Your Ref: OWPC23985
Our Ref: FP/156/19/CLP 17-07-2019
Please ask for:
Amber Willard

Lawful development certificate for proposed erection of detached outbuilding and 2 No. ground floor windows on south elevation.

7 Castlereagh Green Felpham

Drawing Title: PROPOSED STUDIO

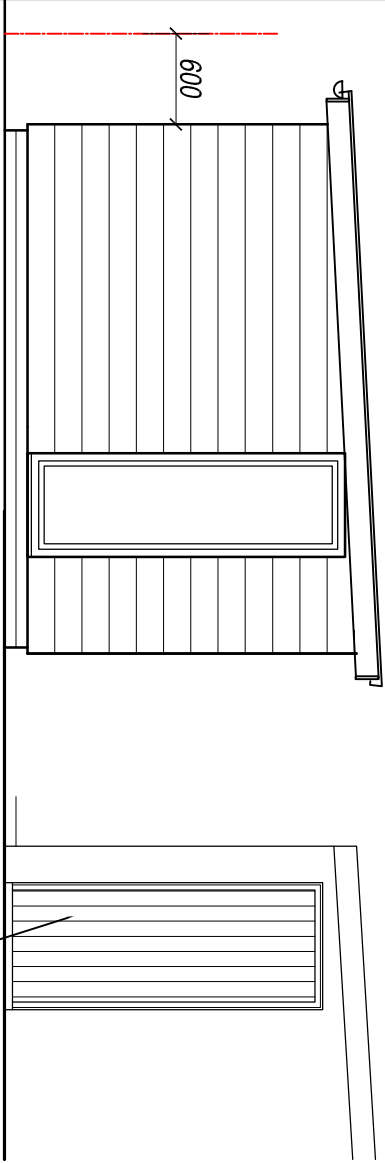
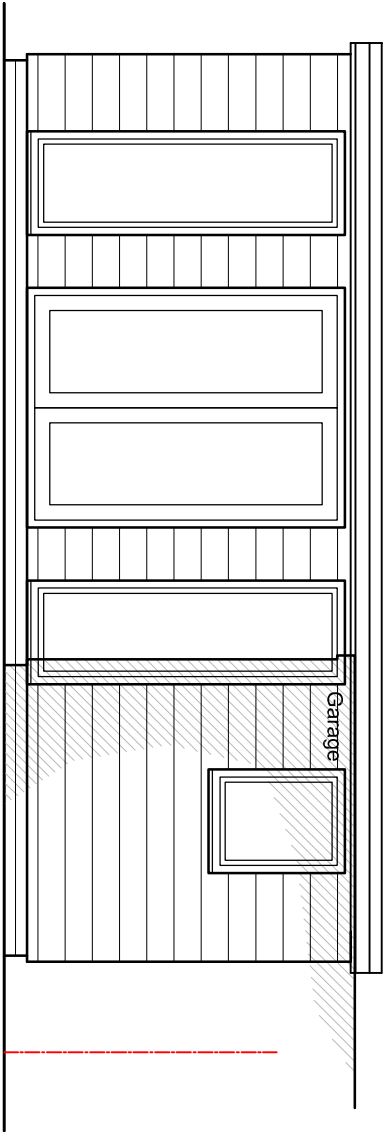
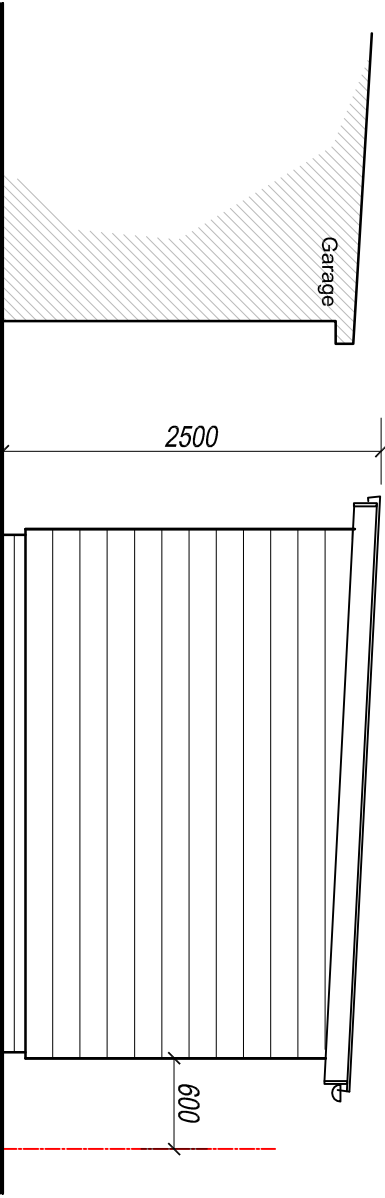
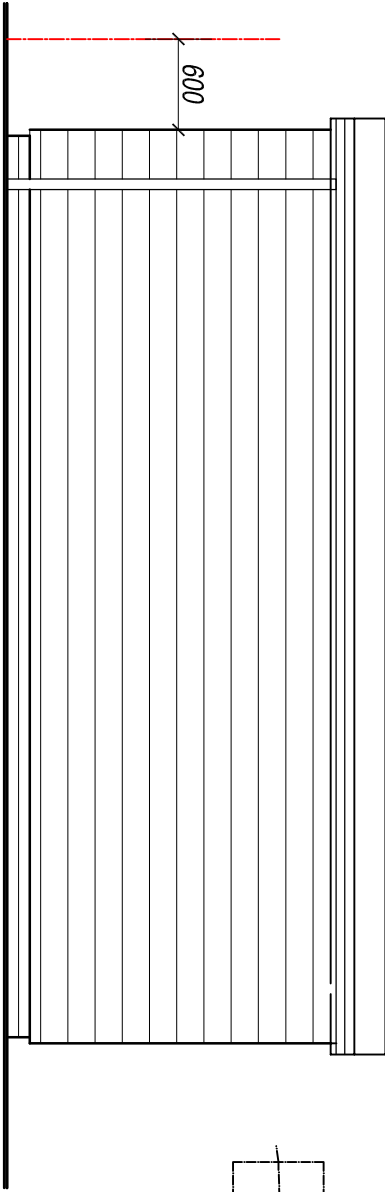
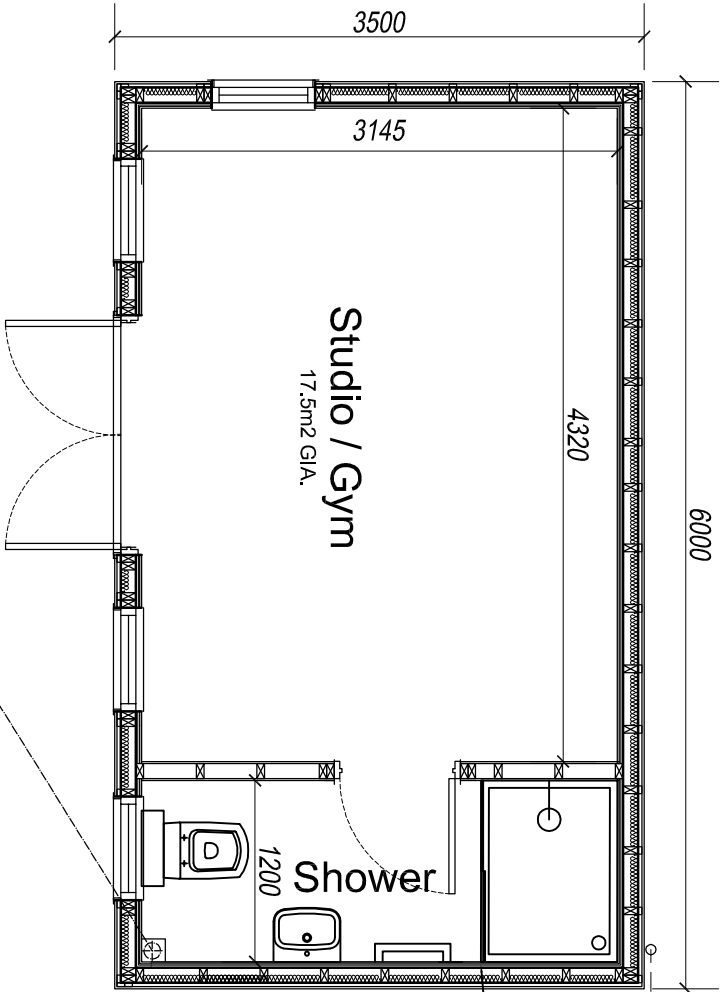
I also object to the proposed separate dwelling for gym & studio with shower room & Wc. I am concerned it will be used as a separate dwelling possibly for a business.

House Side Elevation Proposed (South)

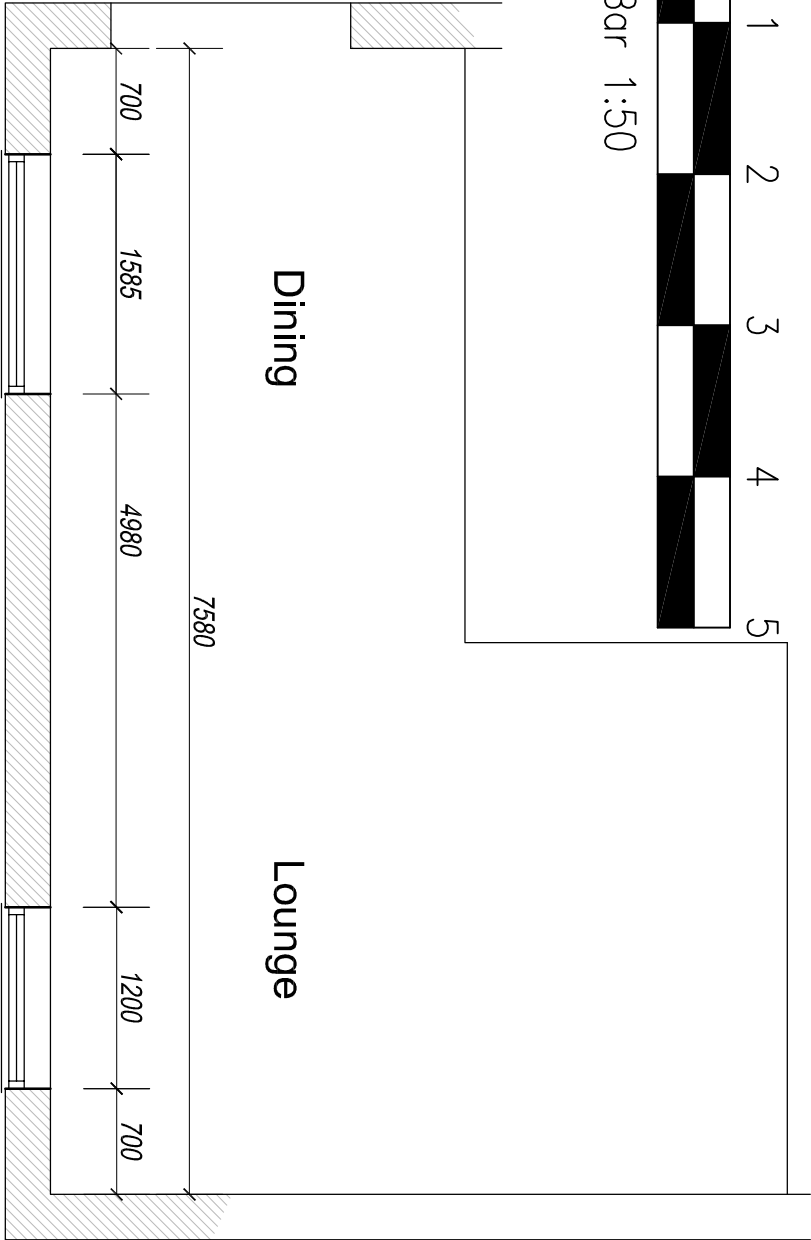
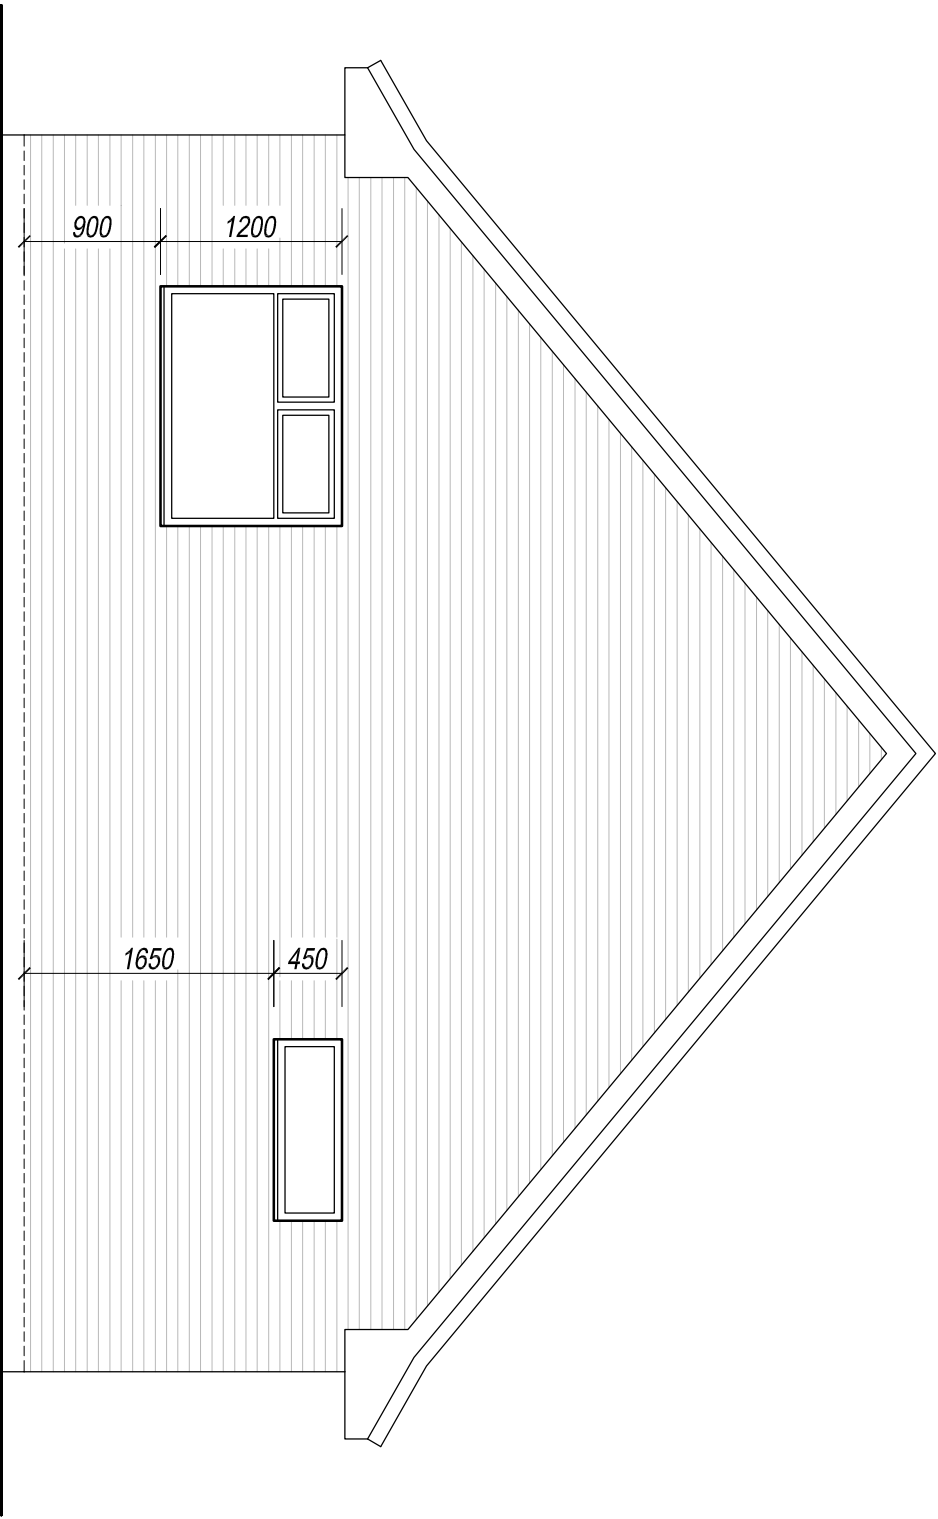
I live at number 5 & the 2 Windows have already been installed. The front one is opposite my lounge window & is unnecessary as it is at right angle to a large floor to ceiling window. It is an invasion of my privacy.
